From: David Easton
Sent: 06 November 2018 09:31
To: 'Jen Samuelson'; Claire Potts; Daniel Vick
Cc: 'Robin Pearmain (Linden Homes)'; 'Stephen Clark (Linden Homes)'; 'Yuved Bheenick (Linden Homes)'; 'Robin Shepherd'
Subject: RE: New Barn Lane: BE/78/18/RES minor amendments

18-1054-001-1st

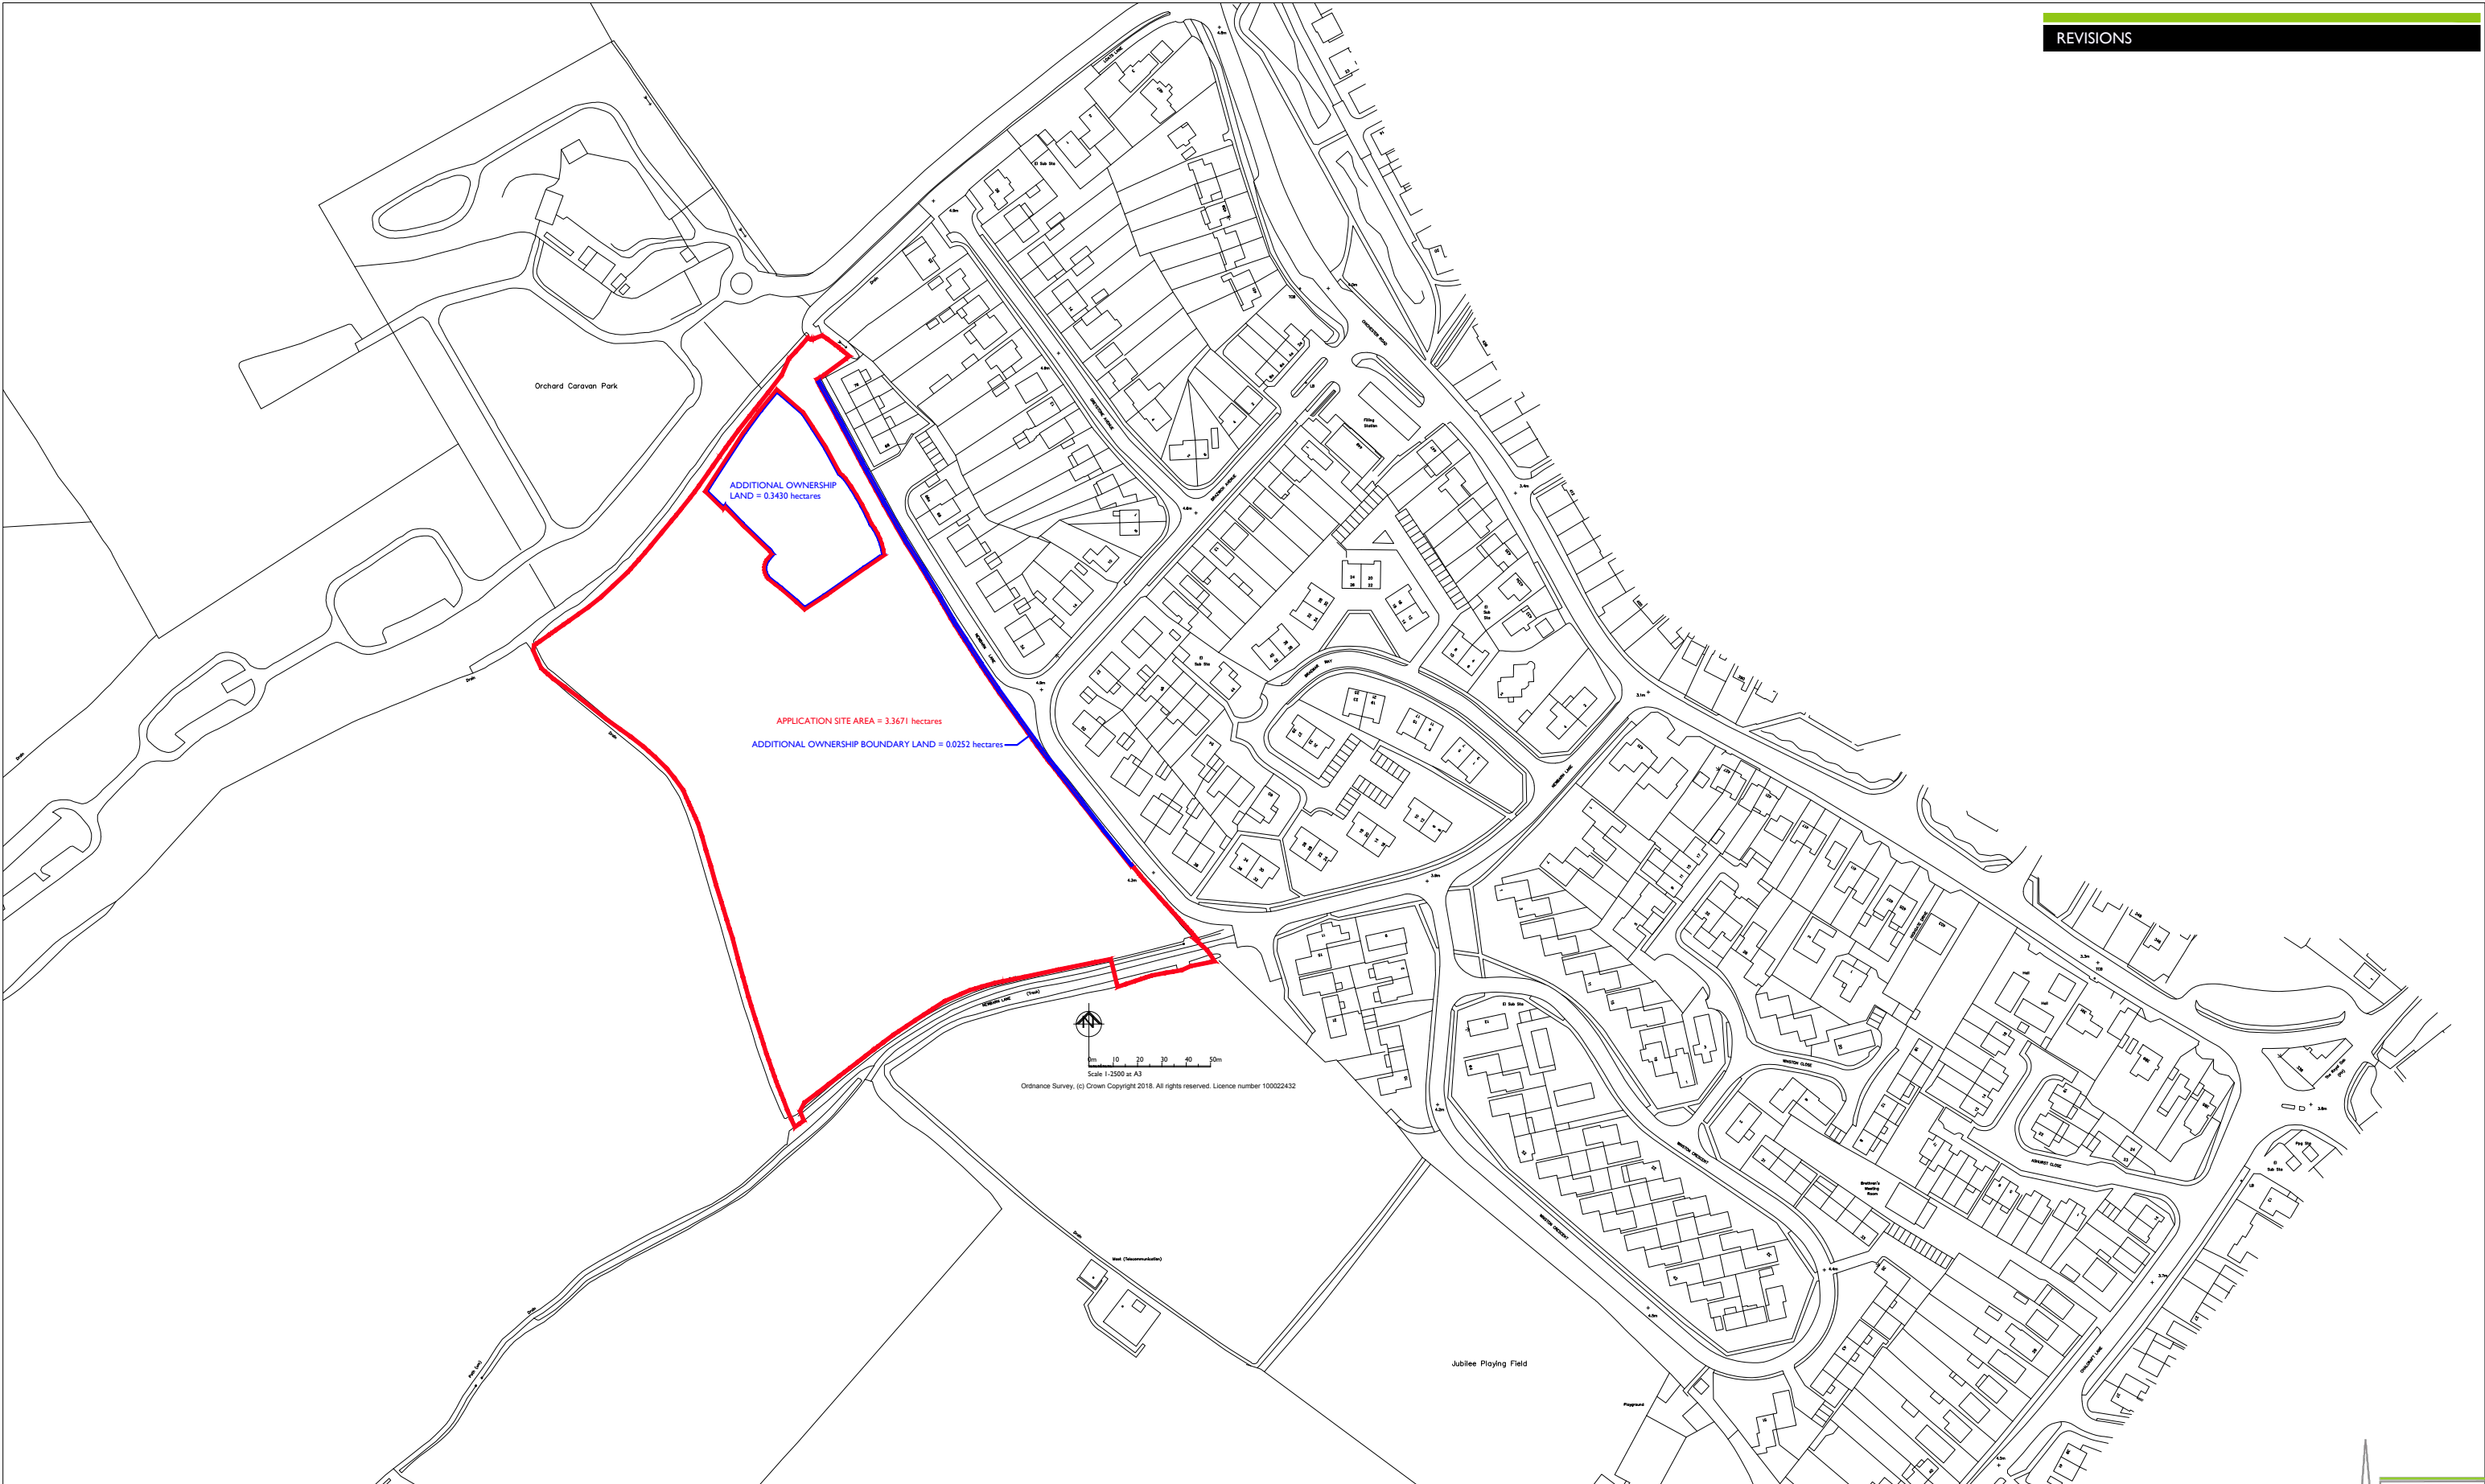
- *Minor re-siting of Plots 9 and 10 to the west, with parking provided in neighbouring garage. Resultant increase in open space adjacent to Plot 9.*

I do question the assumption that the proposed relocation of the dwellings results in any significant increase in the provision of open space on the site. The amended location sees a footpath incorporated forward of the primary elevation of Plot 9 which appears to segregate the dwelling and a portion of open space from the existing provision. Therefore, this space appears more 'private' rather than public being situated immediately forward of the primary elevation. However, I do not see any issue with the amended siting of the dwelling and relocation of the parking provision associated with these plots.

- *Allocation of parking spaces for plots 43-47 & 49 within the parking court (2 spaces per unit)*

I do have concerns with this approach and the loss of any visitor parking associated with the flats. There, is no visitor parking spaces situated in the immediate vicinity of these flats (although I see that additional visitor parking is proposed along the western boundary of the site) I do not believe that visitors to the flats will make use of this parking by virtue of its proximity to the flats. I would still like to see confirmation that the proposed parking provision on site complies with the WSCC parking demand calculator.

- *Provision of 6 additional visitor spaces along western green strip*

As identified above I would like to see confirmation that the parking provision complies with the WSCC parking demand calculator. Similarly, I would wish for confirmation of the open space provision on site to confirm that this meets the minimum requirements for the 100 dwellings now proposed. I would request that a plan is demonstrating the open space provision on site and setting out the total provision of the revised layout. There are a number of areas which result in the loss of open space provision and it would be interesting to see what impact this has had upon the total provision.
